TECHNICAL NOTE

Reference: P1047t03v01

Response to Submissions

New Catherine Field Public School, O’Keefe Drive, Oran Park (SSD 9477)

CATHERINE FIELD PS  
NEW HIGH QUALITY CLASSROOMS  
DRAWING NAME  
GENERAL ARRANGEMENT PLAN

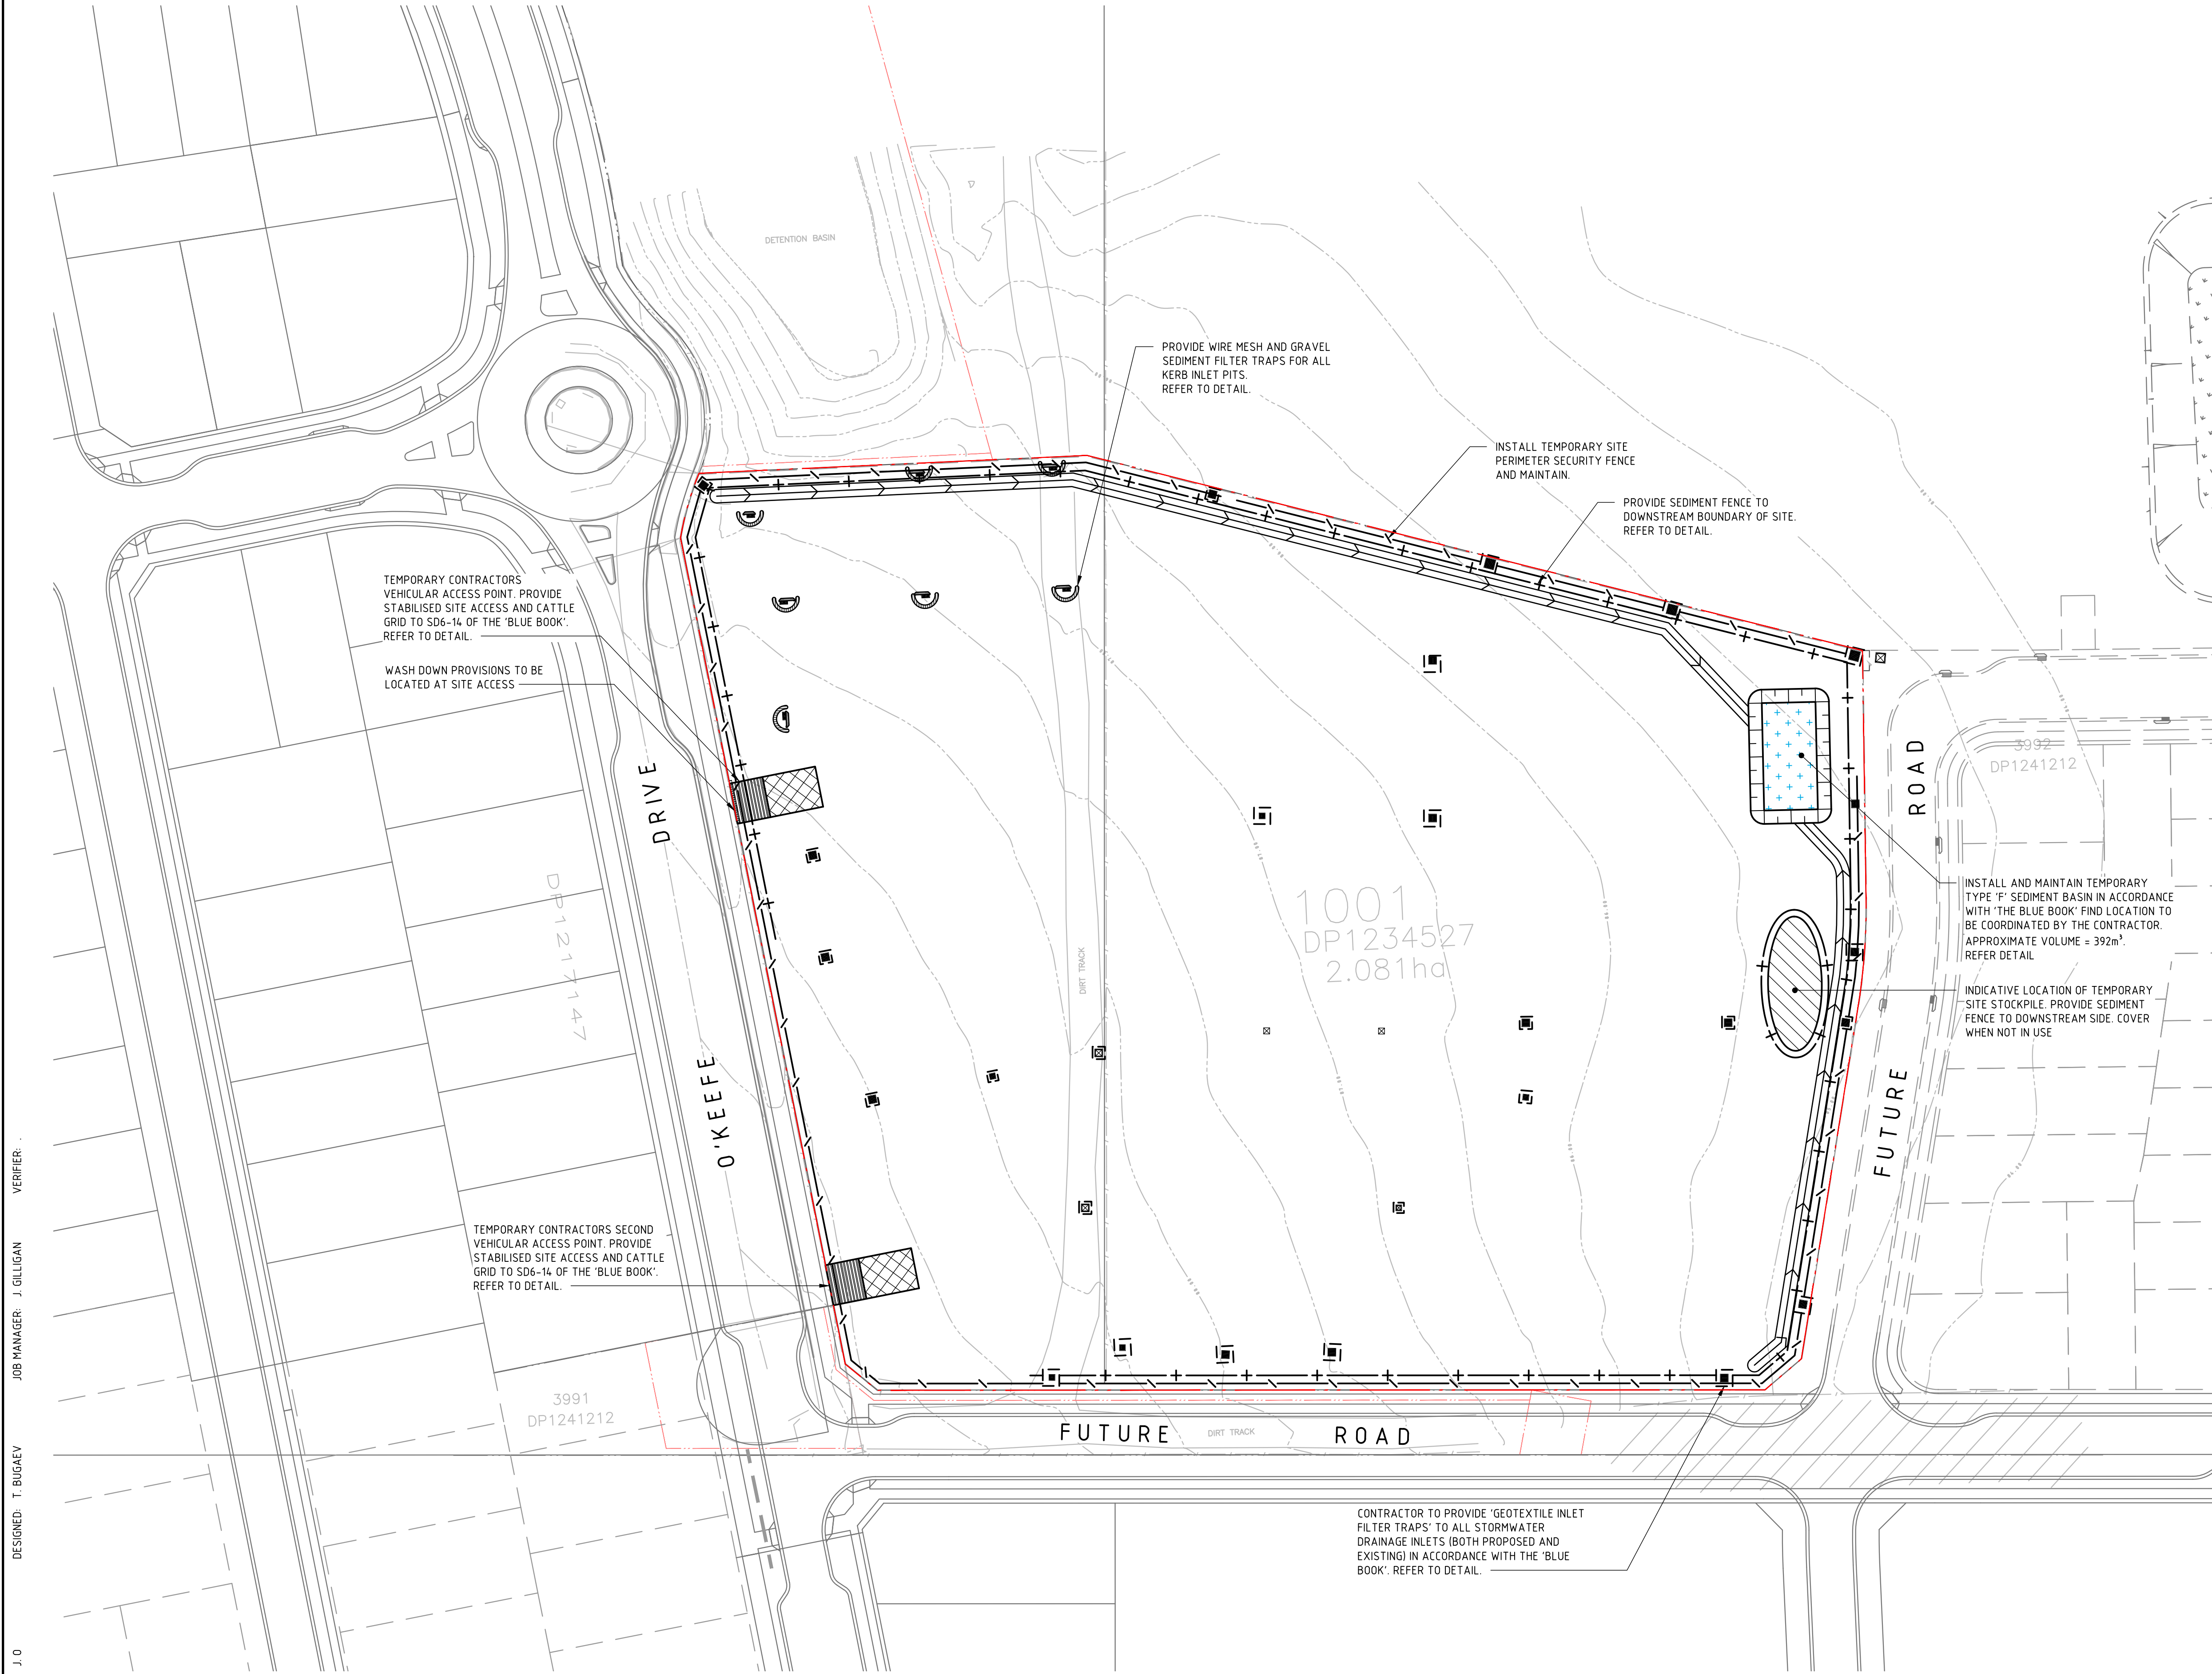
- *School car park access is going through the indented parking lane. Clarification should be provided on how this access will be managed in relation to the parking lane which has already be built on site.*
- *Impact of DOPU activities during school peak hours occurring on key collector road with (future) regular bus services operating on it.*
- *Pedestrian connectivity in relation to accessing (future) bus stops on both sides of O’Keefe Drive, having regard to the school traffic and DOPU activities during school peak hours, should be further reviewed in respect to road safety.).*

The western side of O’Keefe Drive existing residential housing with off- street parking in accordance with the DCP as well as supplementary on street parking. Therefore, it is unreasonable to provide both sides of the road to accommodate their parking requirements. It is assumed that the eastern side of O’Keefe Drive would accommodate the needs of the site on that side. Accordingly—since O’Keefe Drive has been designated as a bus route corridor and as such has been / will be designed in accordance with the appropriate bus standards, including the provision of minimum 3.5m travel lanes and indented bus bays—the indented bus bay on O’Keefe Drive is being provided to accommodate three buses.

In accordance with Section 3 of AS 2890.1, the access to the proposed off-street car park on O’Keefe Drive has been formed in such a way as to be clearly recognised by road users as an access driveway. Additionally, the appearance and character of the driveway is such that it will be clear to vehicle drivers that pedestrians and frontage road traffic have priority of movement.

The Category 2 access is not located in a prohibited location in accordance with AS2890.1, has satisfactory entering sight distance and clear sight lines for pedestrians for the design speed.
